From: Sarah Burrow <Sarah.Burrow@arun.gov.uk>
Sent: 06 January 2020 17:49
To: Planning.Responses <Planning.Responses@arun.gov.uk>
Cc: Amber Willard <Amber.Willard@arun.gov.uk>
Subject: RE: Planning Consultation on: WA/106/19/HH

Engineers Comments Regarding Surface Water Drainage

APPLICATION NO: WA/106/19/HH

Description of Works: Single storey rear extension to accommodate enlargement of
Kitchen /diner

PROPOSED PLANS AND SECTION

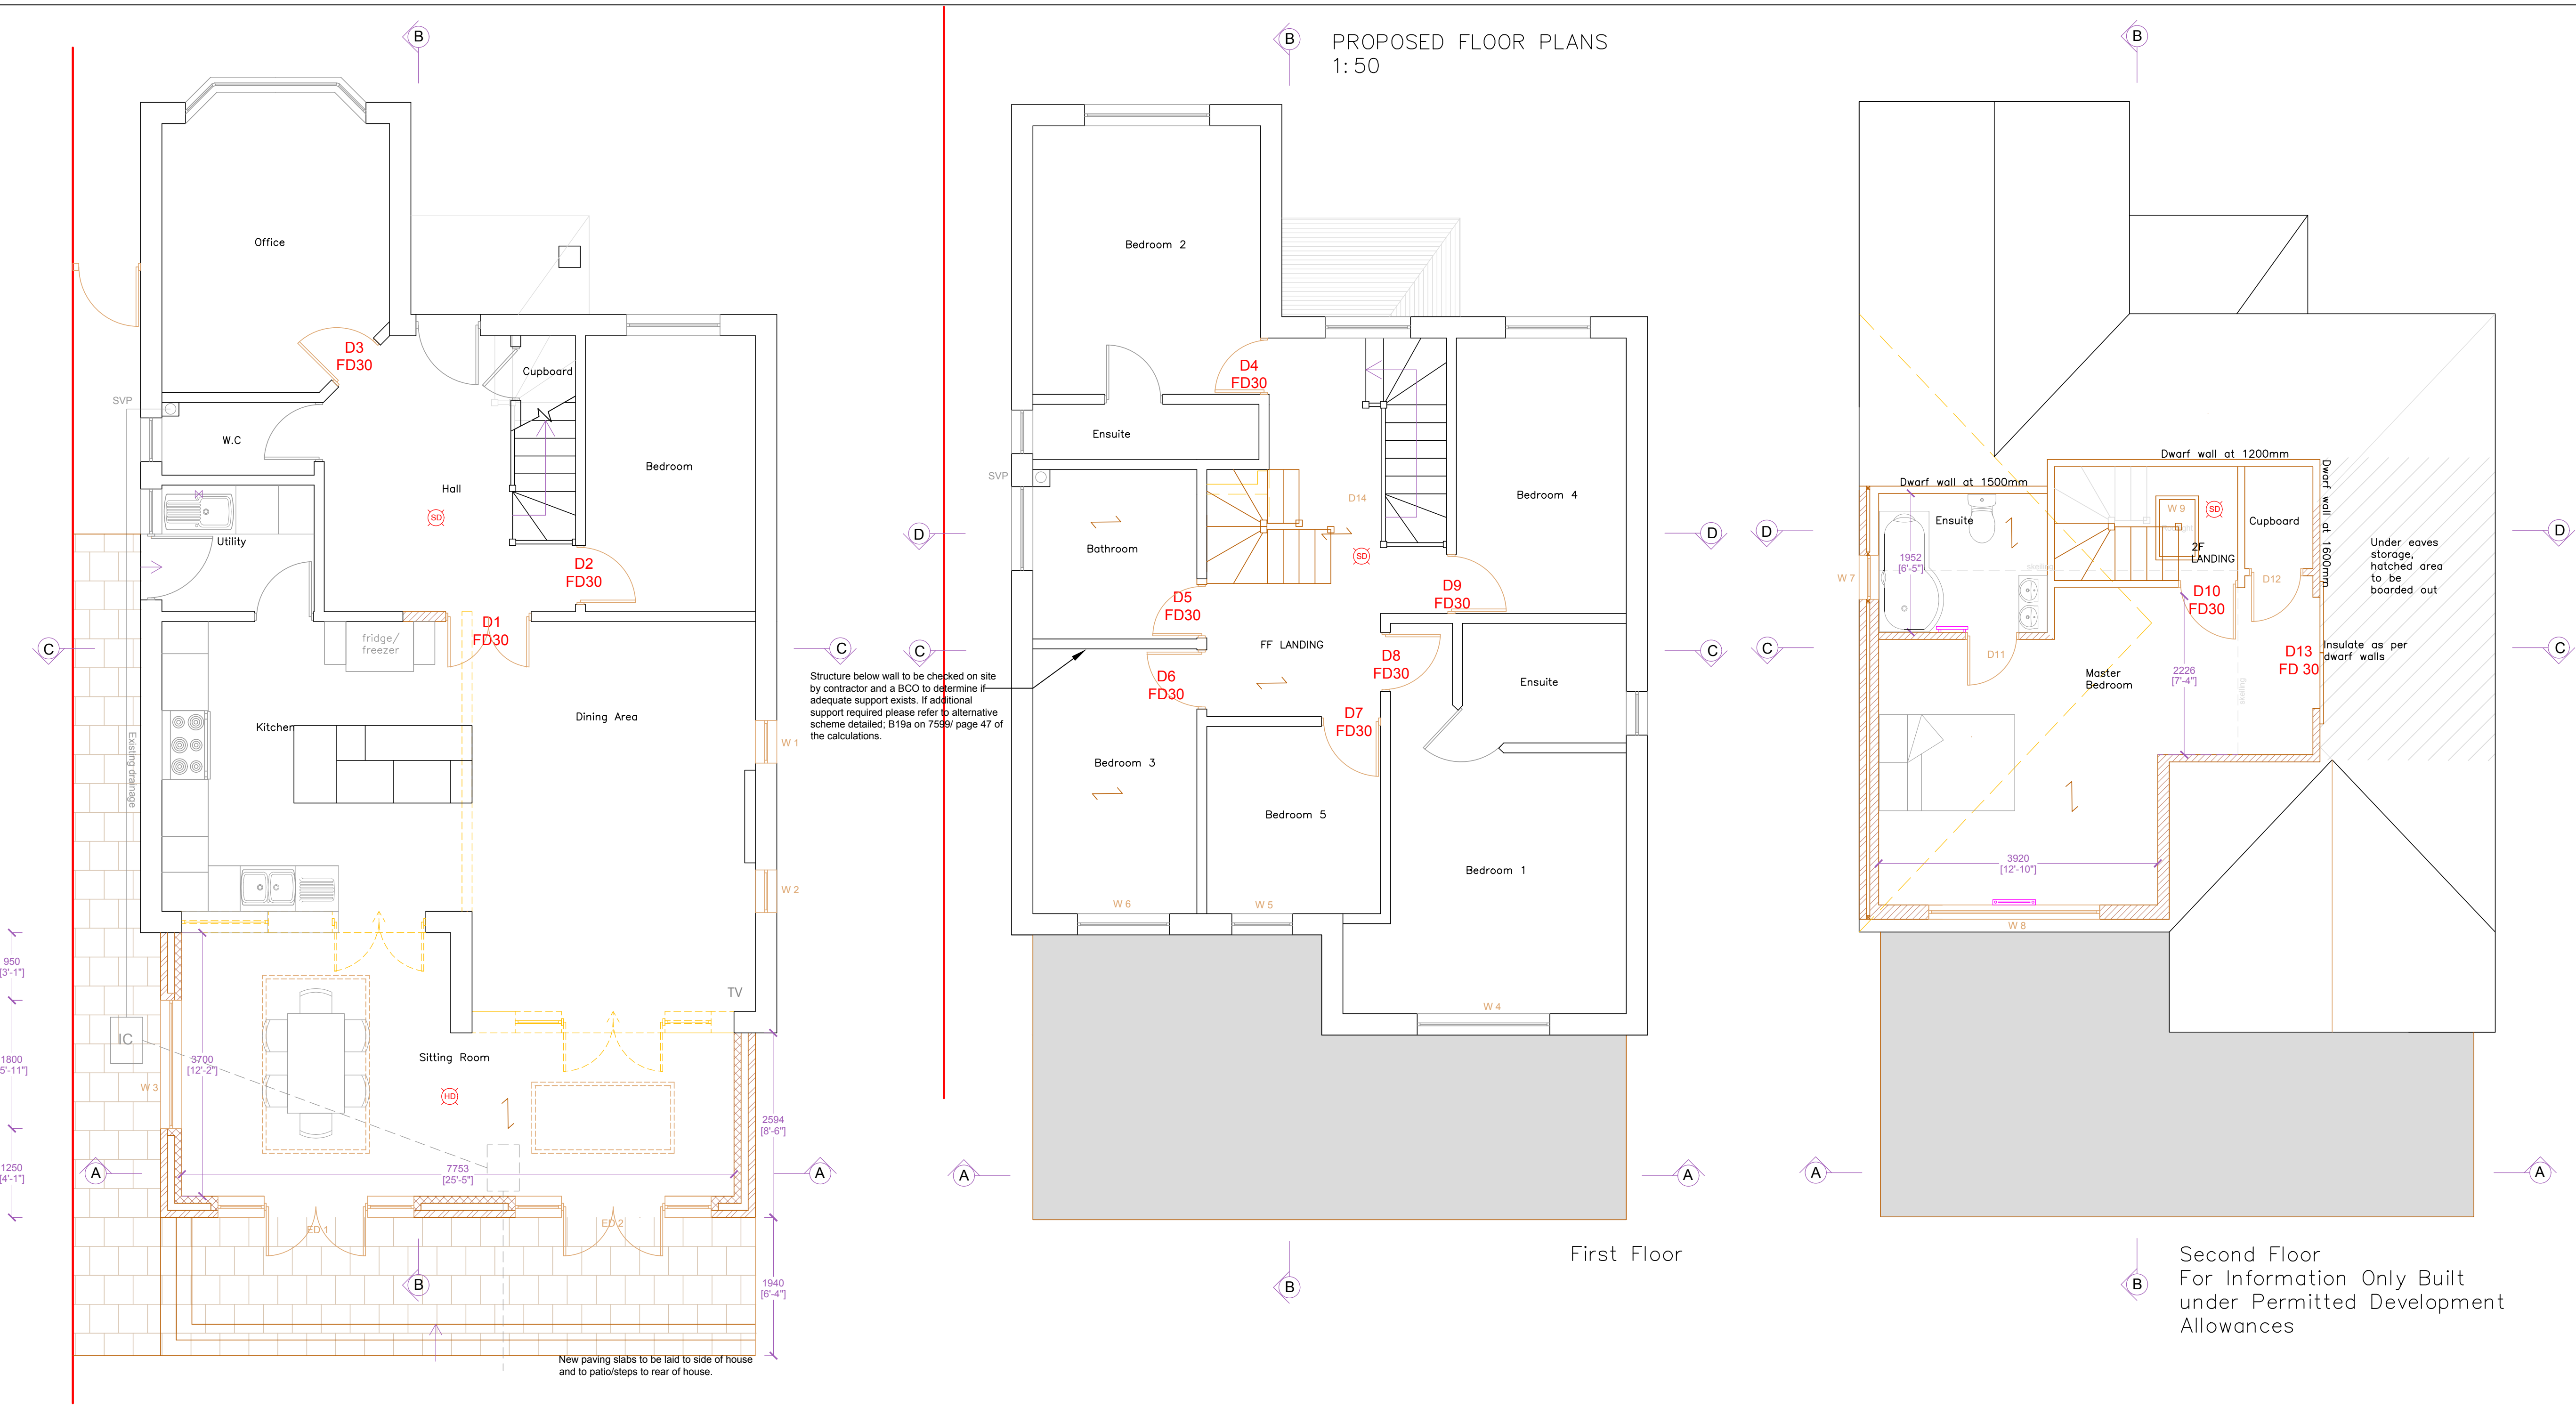
It is understood from the documents that this is a retrospective application. The site is located within the Lidsey Treatment Catchment in which we aim to strictly control surface water and minimise additional surface water to the already overwhelmed sewage system. No information regarding the constructed surface water drainage design has been supplied. It would be usual to request that the following condition be applied to ensure that the site is adequately drained and does not increase flood risk elsewhere. If you are minded to approve the application please apply this condition, unless the applicant is able to provide a surface water drainage design that meets the requirements detailed in the checklist linked below.

"Development shall not commence, other than works of site survey and investigation, until full details of the proposed surface water drainage scheme have been submitted to and approved in writing by the Local Planning Authority. The design should follow the hierarchy of preference for different types of surface water drainage disposal systems as set out in Approved Document H of the Building Regulations, and the recommendations of the SuDS Manual produced by CIRIA. Winter groundwater monitoring to establish highest annual ground water levels and winter Percolation testing to BRE 365, or similar approved, will be required to support the design of any Infiltration drainage. No building / No part of the extended building shall be occupied until the complete surface water drainage system serving the property has been implemented in accordance with the agreed details and the details so agreed shall be maintained in good working order in perpetuity."
